DOC22/198769-23

I refer to your request for advice in relation to the review of the Environmental Impact Statement (EIS) for the proposed Rooty Hill Materials Recycling Facility (SSD-29999239) (the Proposal) at Lot 67 in Deposited Plan DP804292, known as 600 Woodstock Avenue, Rooty Hill NSW 2766 (the Premises).

The EPA has conducted a review of the information provided for the Proposal, including the EIS prepared by Urbis on behalf of Charter Hall Pty Ltd, dated 24 February 2022 and associated documents. The EPA has determined that the SEARs relating to air quality impacts and contamination have been addressed adequately. The EPA has provided comments and recommended consent conditions as required for these environmental impacts (Attachment A).

Environmental Noise Monitoring

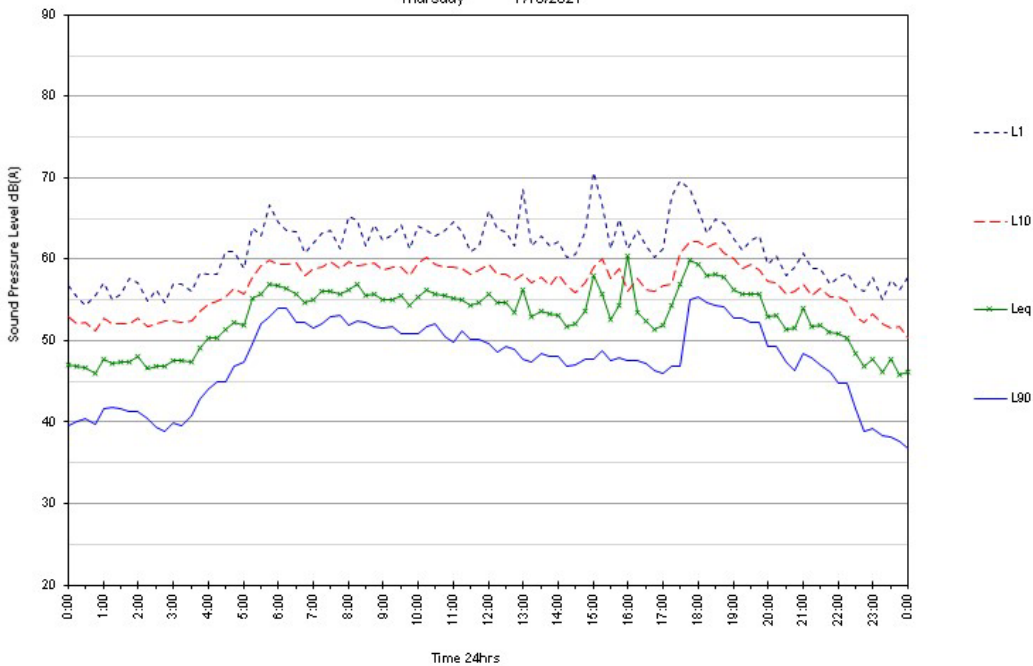
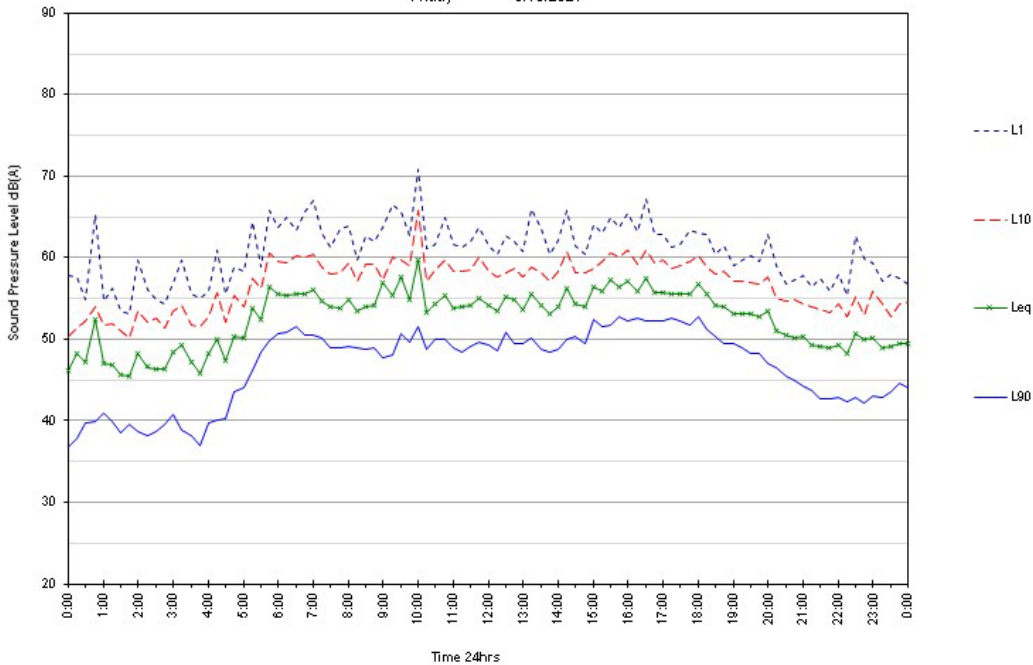
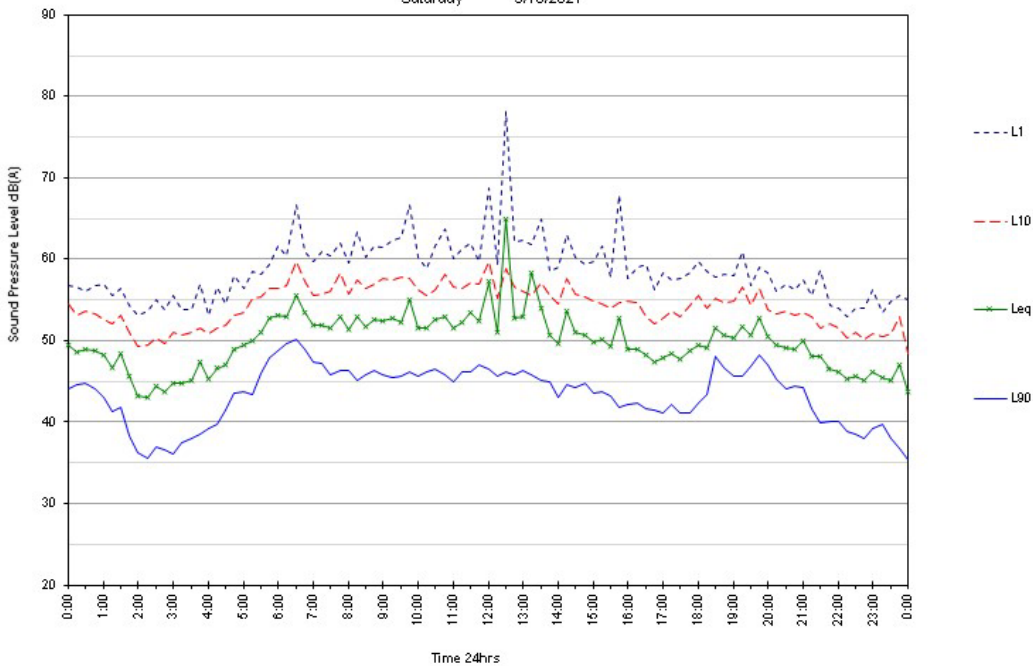
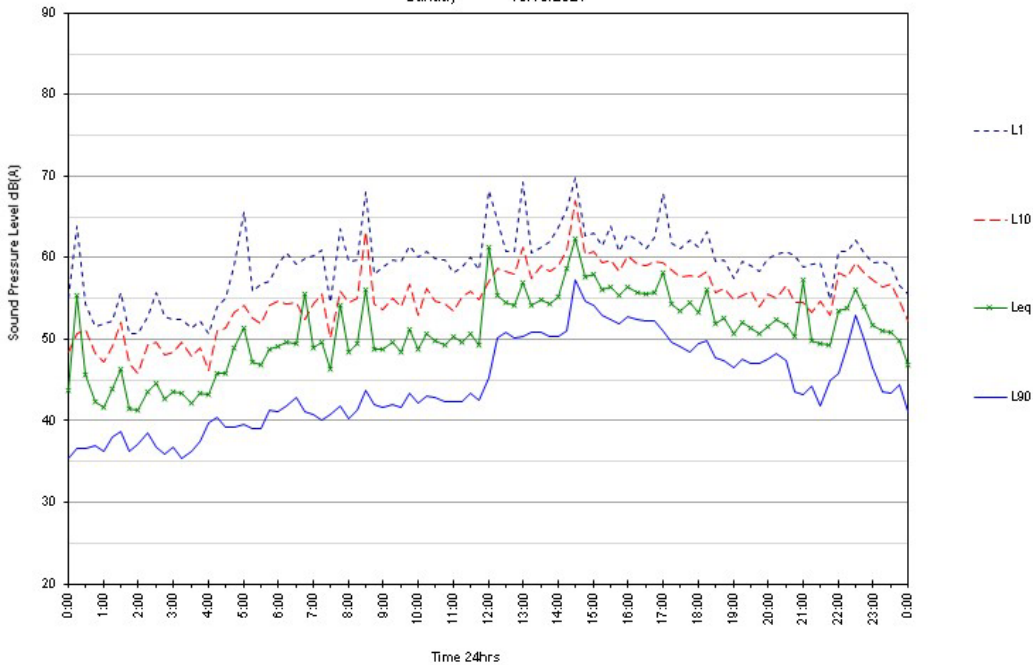
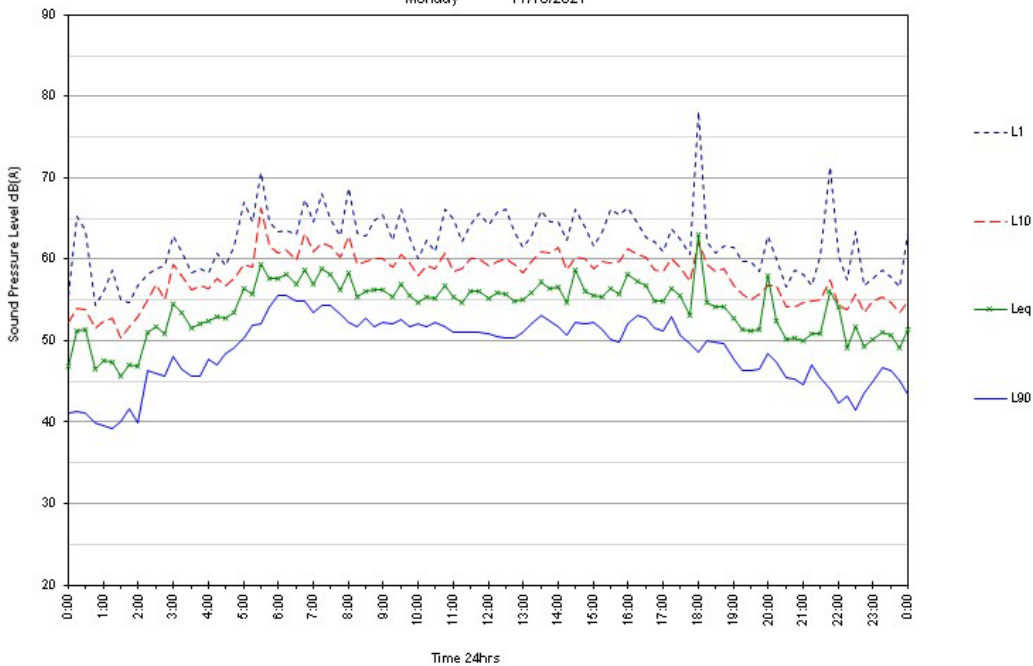
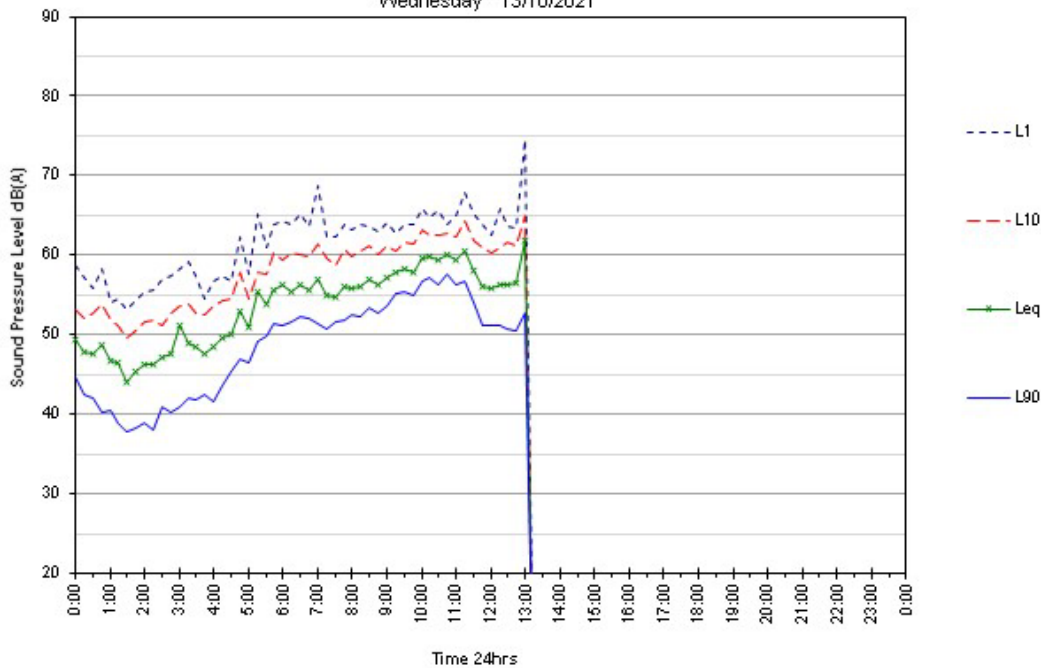
3. Section 5.3 of the AR states the background noise monitoring was carried out between 5 and 13 October 2021, however data is only presented for a seven-day period between 6 and 12 October 2021 in Table 3. Furthermore, Table 2 shows that significant rainfall was recorded on Monday 11 October, and Table 3 shows that extraneous noise was present on Thursday 7 October. It is likely that the total duration of valid background noise data falls short of the minimum one week of valid data specified in Table A1 of the Noise Policy for Industry (NPfI). Furthermore, the meteorological data in Table 2 shows only spot wind readings at 9am and 3pm, and no information to confirm the validity of readings at other times of each day is available.

- a) The Applicant must provide wind speed and rainfall data, ideally overlaid as traces on the daily noise logger charts, to confirm the validity or otherwise of each 15 minute data point in the background noise monitoring data. Any 15 minute periods affected by excessive rain or wind should be removed from the data set as per Fact Sheet A and Fact Sheet B of the

NPfI. A minimum of 7 days' valid background noise monitoring data must be provided in the assessment.

1 SITE / GROUND FLOOR
1:400

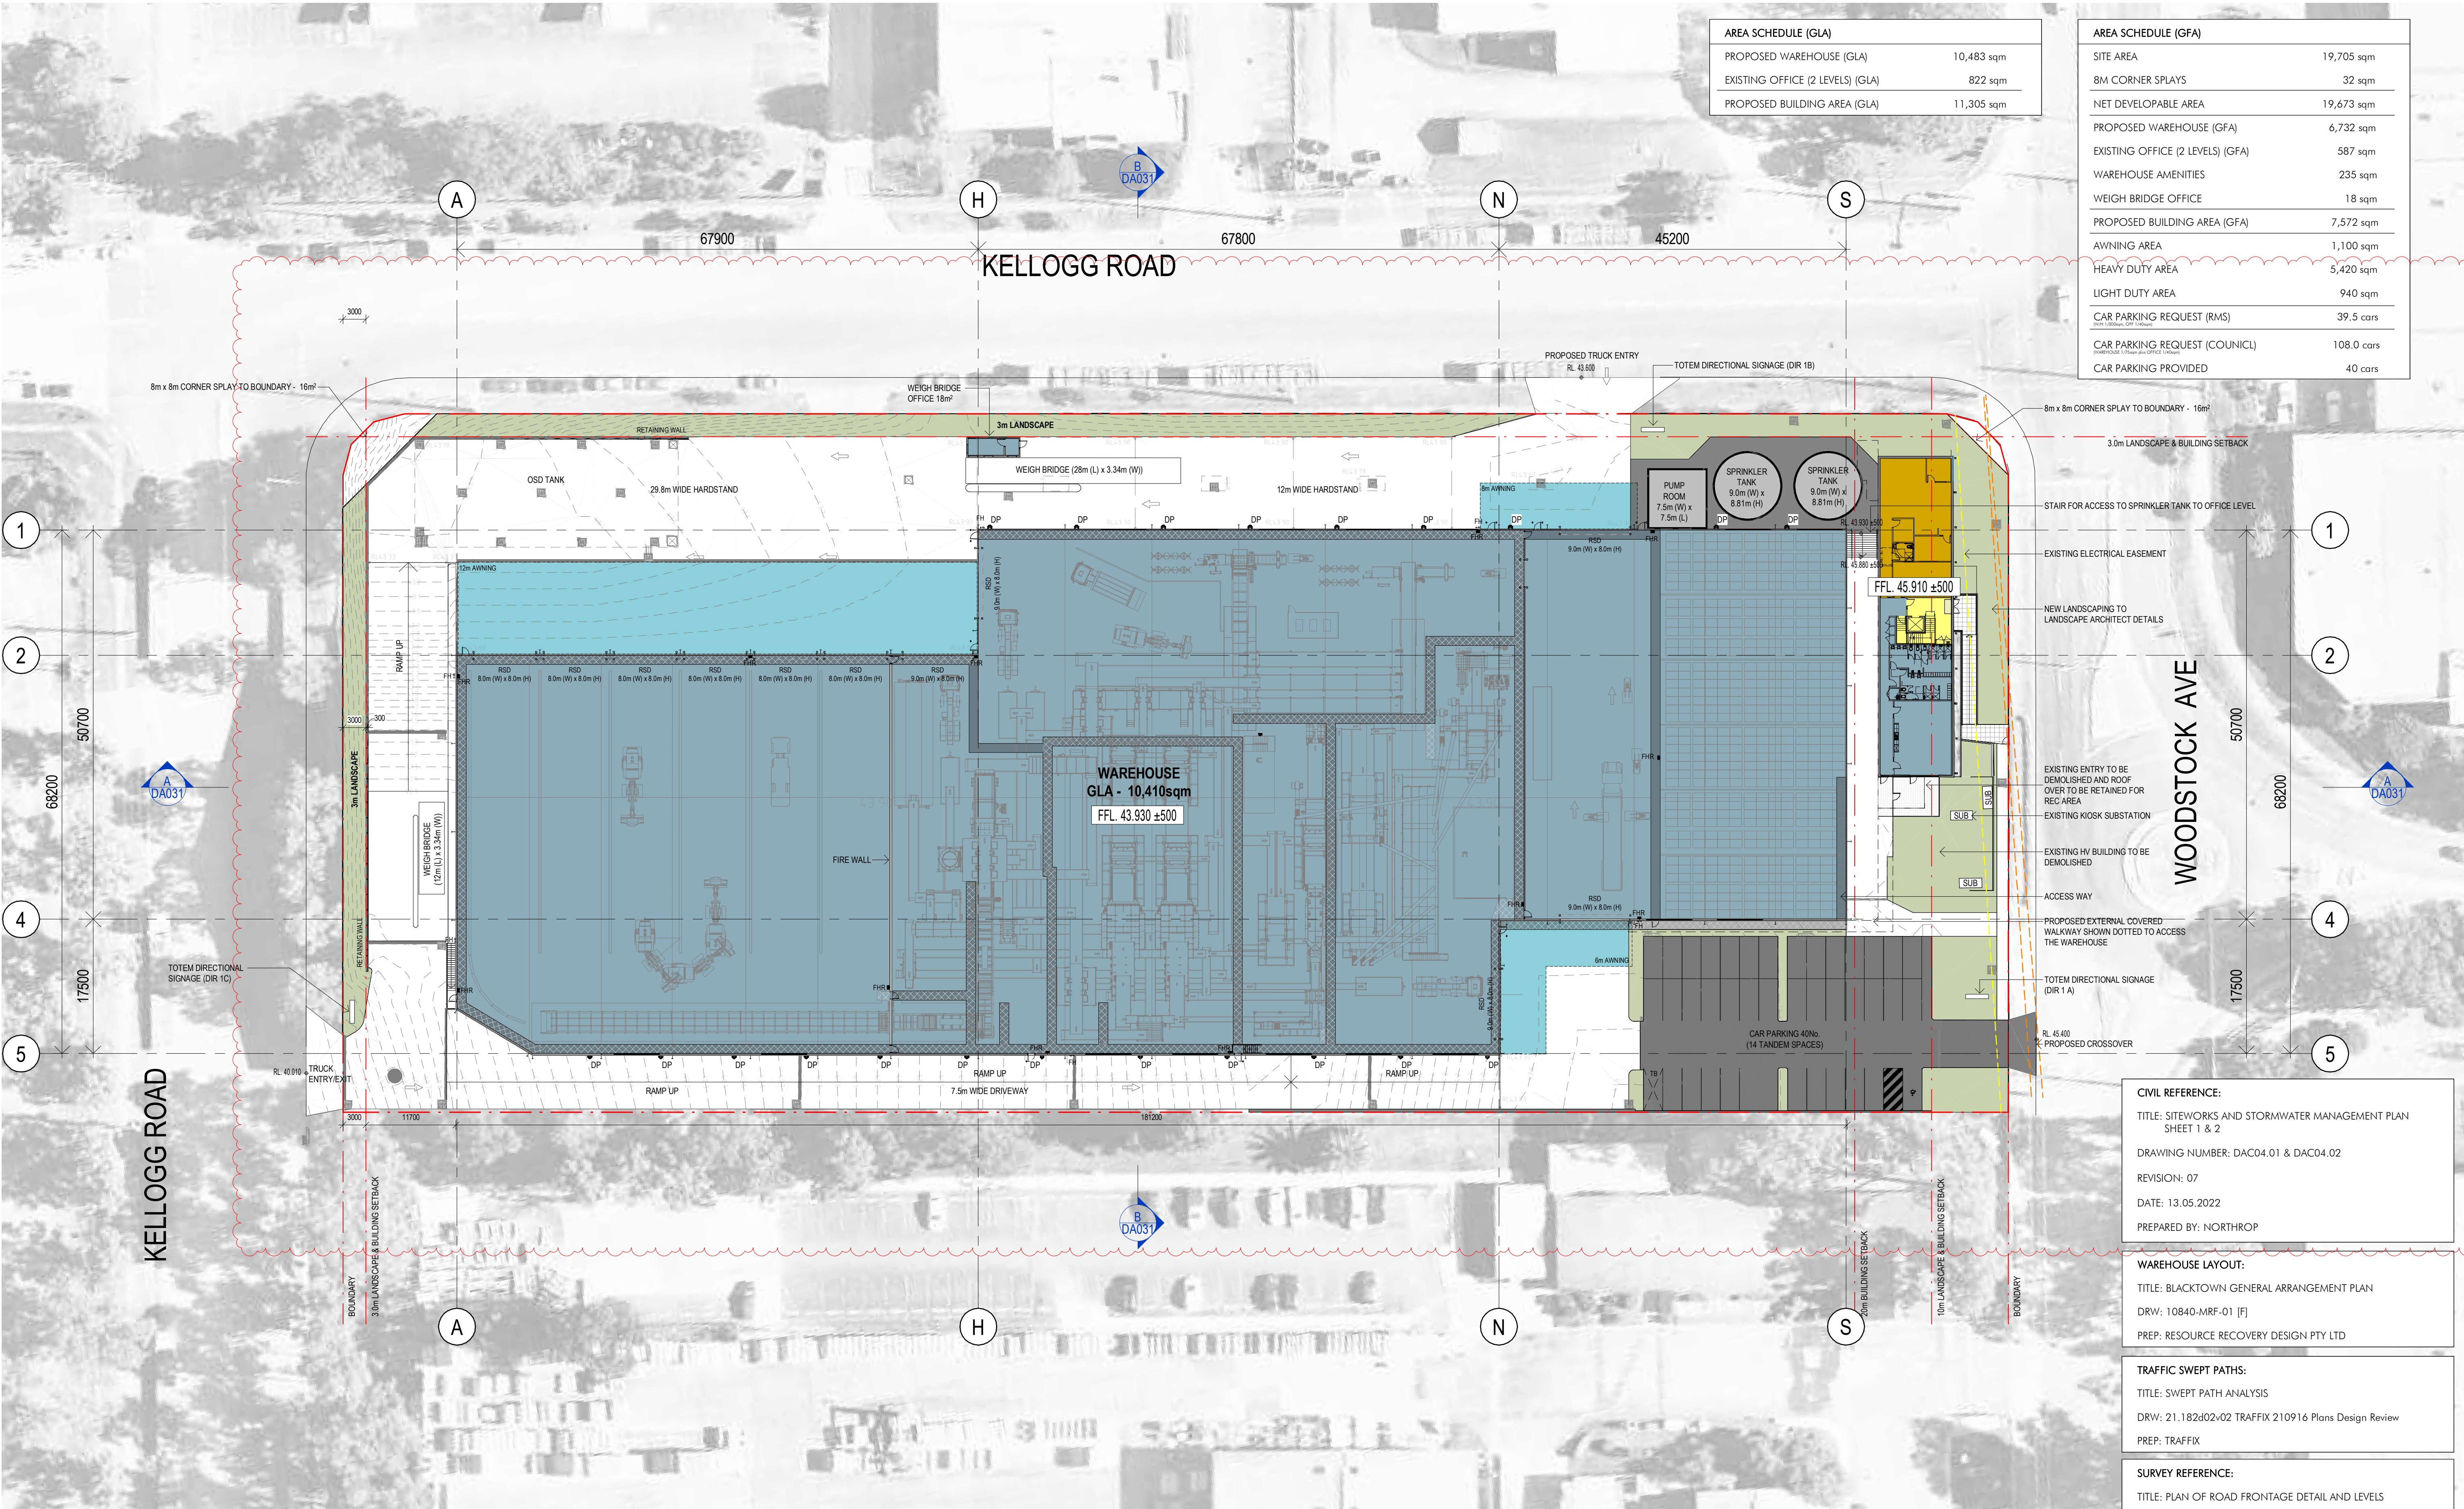
1. The EPA has reviewed the EIS and the Architecture Plans prepared by Nettleton Tribe dated December 2021 provided at Appendix B, the Waste Processing Stream Overview prepared by Resource Recovery Design Pty Ltd dated 9 February 2022 provided at Appendix BB, the Waste Management Plan (WMP) prepared by SLR, dated February 2022 provided at Appendix L of the EIS. Insufficient information has been provided with the EIS in relation to site design and it is unclear from the EIS where each waste type will be stored and the infrastructure associated with waste storage, including the design for any waste storage bays and location of skip bins.

2. The EPA notes that the EIS describes incoming feedstock to be contained in six separate bunkers however the Waste Management Plan (WMP) prepared by SLR, dated February 2022 provided at Appendix L provides descriptions and diagrams indicating five receiving bunkers.

- a) The Applicant must provide a site plan identifying, at a minimum, the following areas:
  - i. Haulage
  - ii. Waste receipt, processing, storage and loading (for each waste type)
  - iii. Quarantine
  - iv. Infrastructure for environmental controls including dust, noise, water and wheel wash
  - v. Weighbridge/s
  - vi. Site boundaries
  - vii. Stormwater drainage areas
  - viii. Chemical and fuel storage areas
  - ix. Processing equipment and infrastructure
  - x. Machinery storage areas.
- b) The Applicant must clarify the receiving bay configuration and ensure that all documentation accurately reflects the proposed arrangement.
